Our Ref: LU/210/19/PL

Development Demolition of the existing vacant dwelling and workshop and the erection of 10 detached dwellings (9 dwellings net) - Resubmission of LU/133/19/PL

Location Inglecroft Toddington Lane, Littlehampton,

PLOTS 1 - 10 FLOOR PLANS

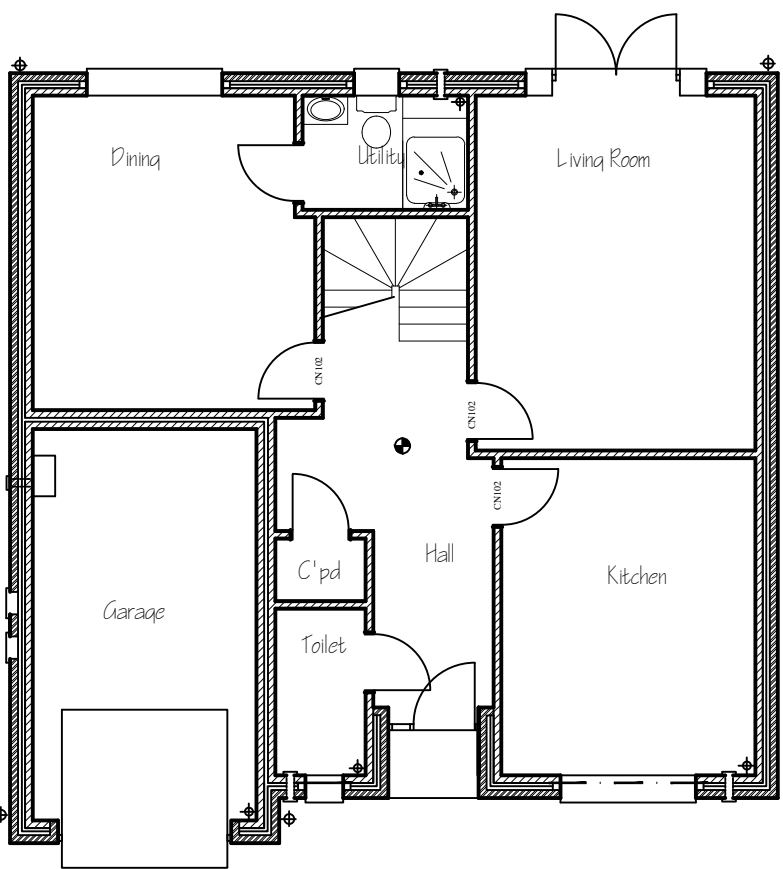
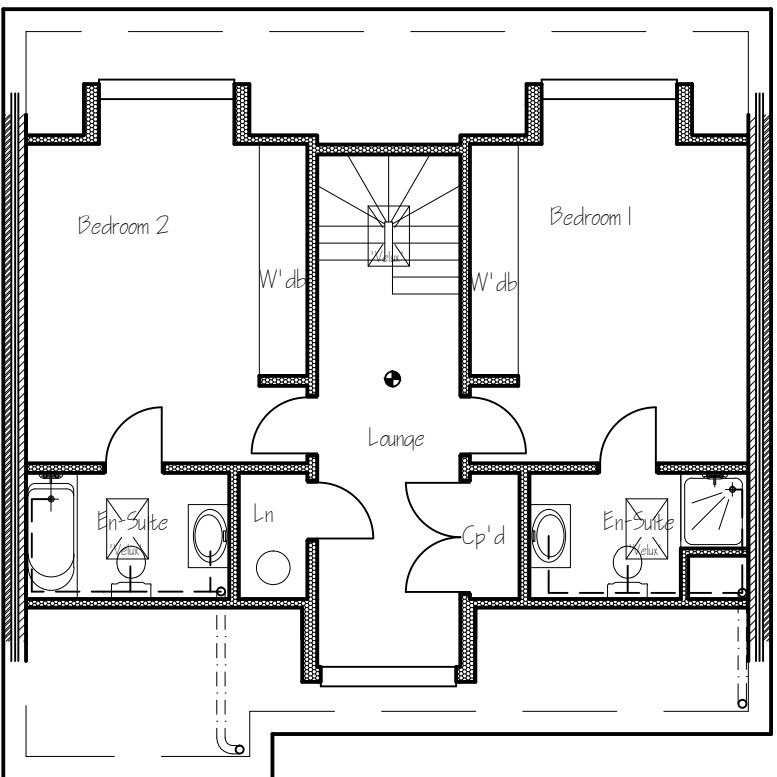
The information provided on the Residential/Dwelling Units - Supplementary Information Template does not match the floor plans. Floor plans show 2 bedrooms, the template shows them as 3 beds. Please forward amended plans and/or template accordingly.
